Appeal NO: ABP 314485-22Defer Re O/H ☐Having considered the contents of the submission (dated) received 28/03/2024
fromJohn Yeates I recommend that section 131 of the Planning and Development Act, 2000
be (not be invoked) at this stage for the following reason(s): no new material issuesE.O.: Pat BDate: 08/04/2024

RE: Case Number ABP- 314485-22 Relevant Action Application Dublin Airport

Figure 3.1 – Regulatory Decision, Third Condition.
Residential Sound Insulation Grant Scheme (RSIGS) - Initial Eligibility Contour Area - June 2022

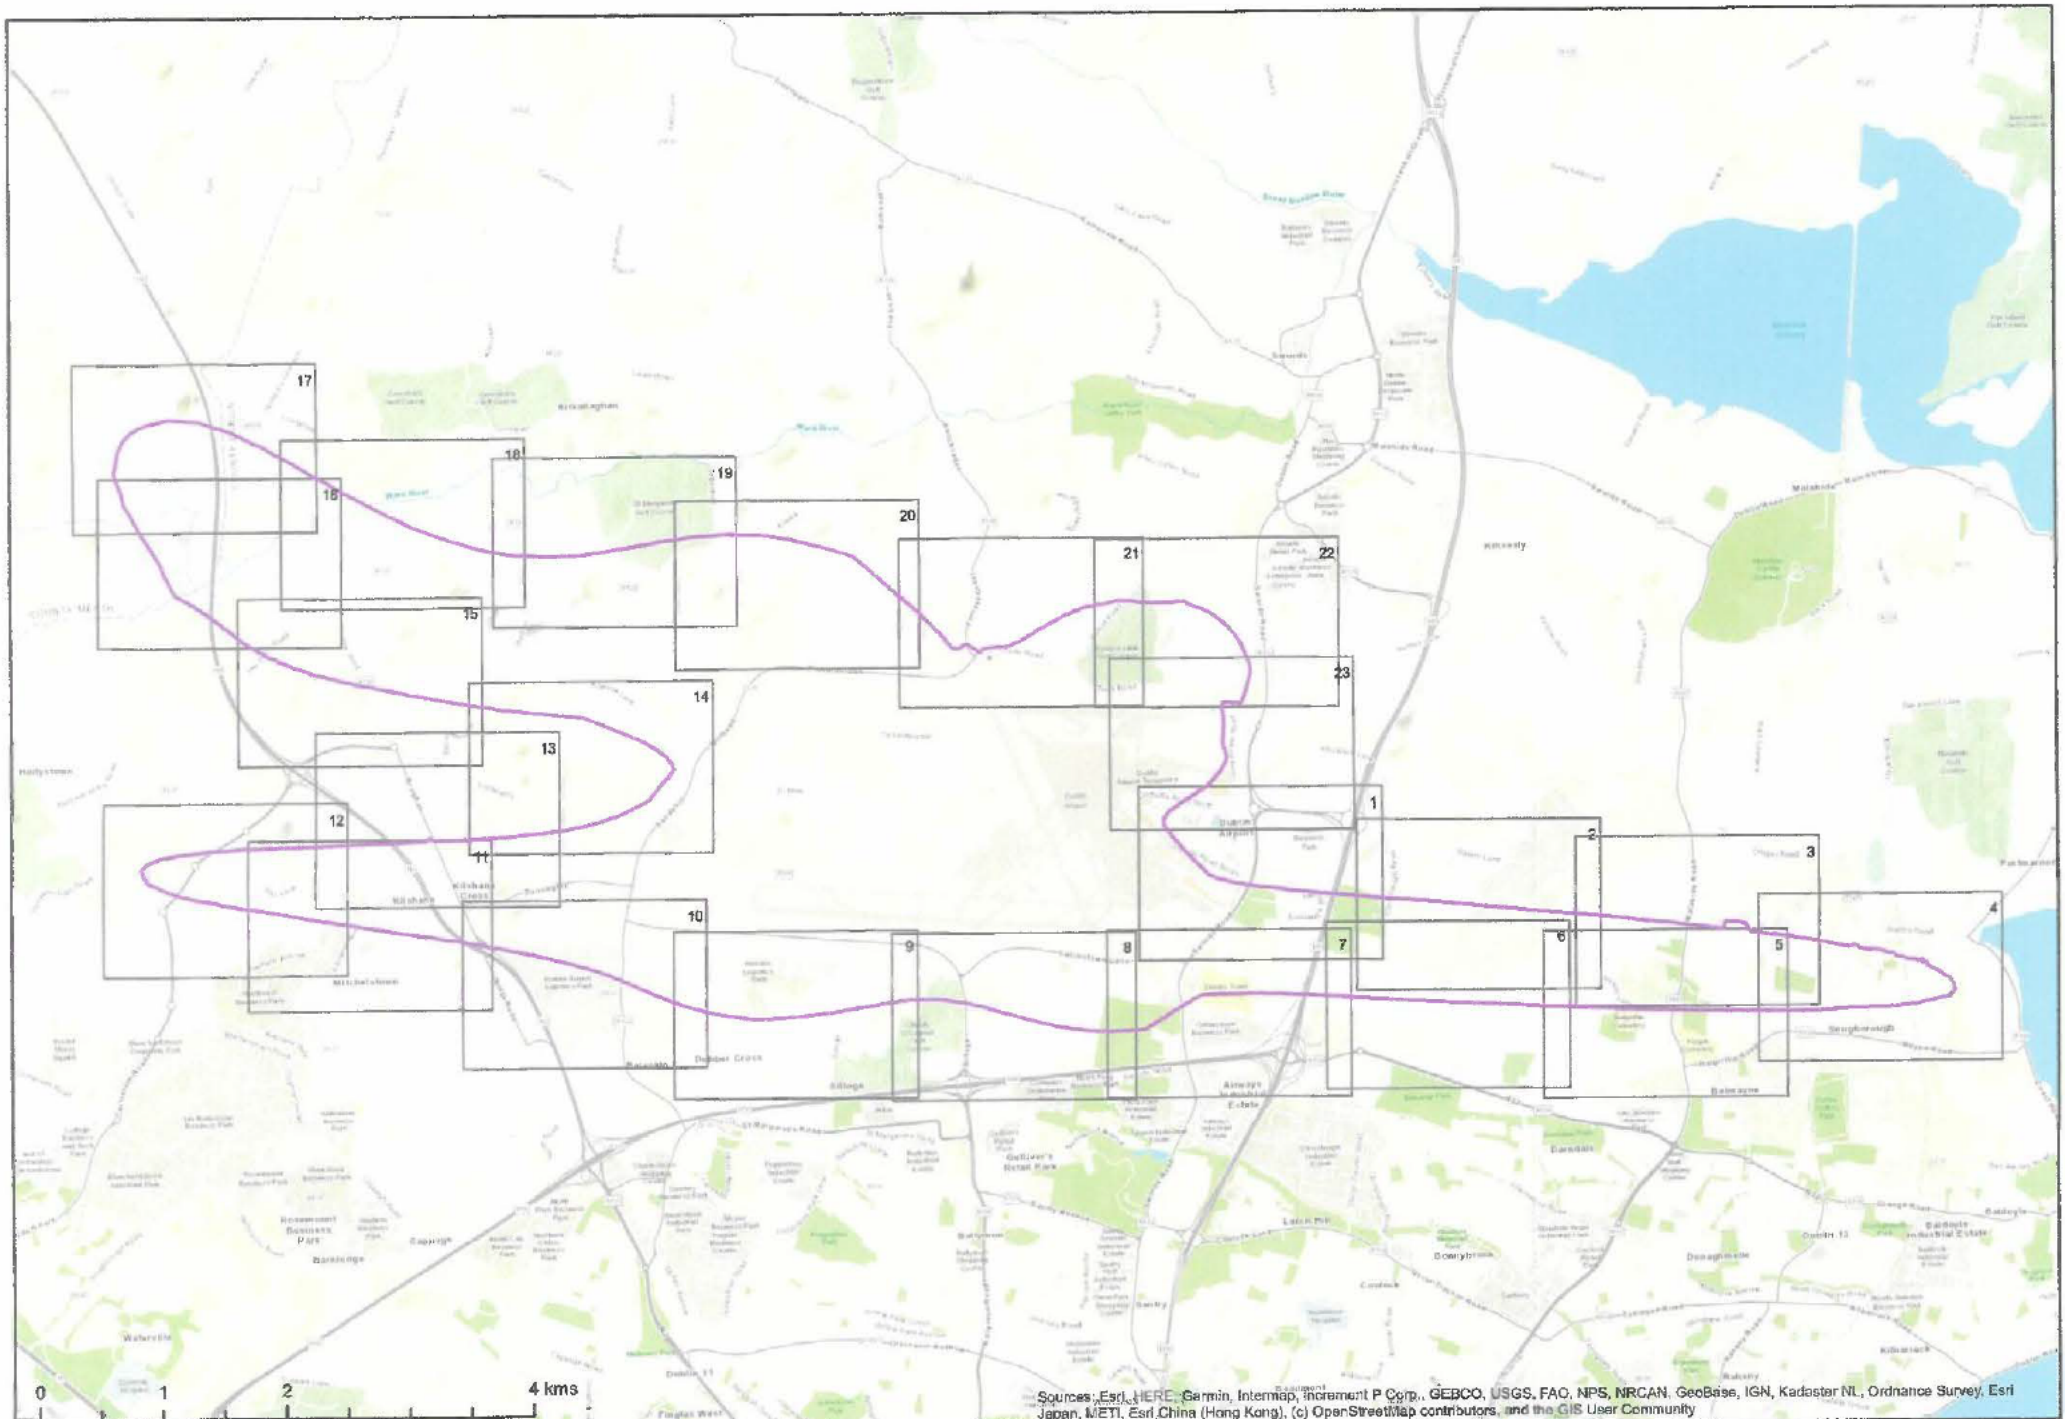
1. We are shocked to see that the noise contours have extended hugely into our community and that a very significant number of dwellings are now included within the noise eligibility contours. Firstly, we note that there was no notice of this fact in any of the planning notices for this application to date. Many of our neighbours who thought they were not affected by this application are now inside these contours but yet were never publicly notified until they attended a public meeting held by St Margarets /The Ward residents' group who explained this to all of us. None of the newspaper or site notices informed the public. Secondly, the people who now know they are within the contours have not been given the opportunity to make a submission/observation as they do not qualify because they did not make a submission previously as they thought they were unaffected. An Bord Pleanála did not give a public notice of this significant additional information. The above is totally unacceptable and unjust to the communities affected.

2. We note that the correspondence from Tom Phillips & Associates refers to the ANCA Regulatory Decision regarding eligibility to the noise insulation scheme and suggest that the change in contours is as a result of their assessing that the increased area is as a result of them considering this new area which contains dwellings to having "very significant" effects. We note that the DAA have never carried out significant test criteria within any of the EIAR they have submitted and therefore they have not met with the EIA directive. This is a fundamental flaw in the assessment as the EIA directive is clear, all significant impact on environment must be identified, quantified and mitigation proposed. That has not happened to date. For areas under the North Runway this involves comparing the scenario with no flights from the North Runway to a scenario where there will be night flights. This has not been done.
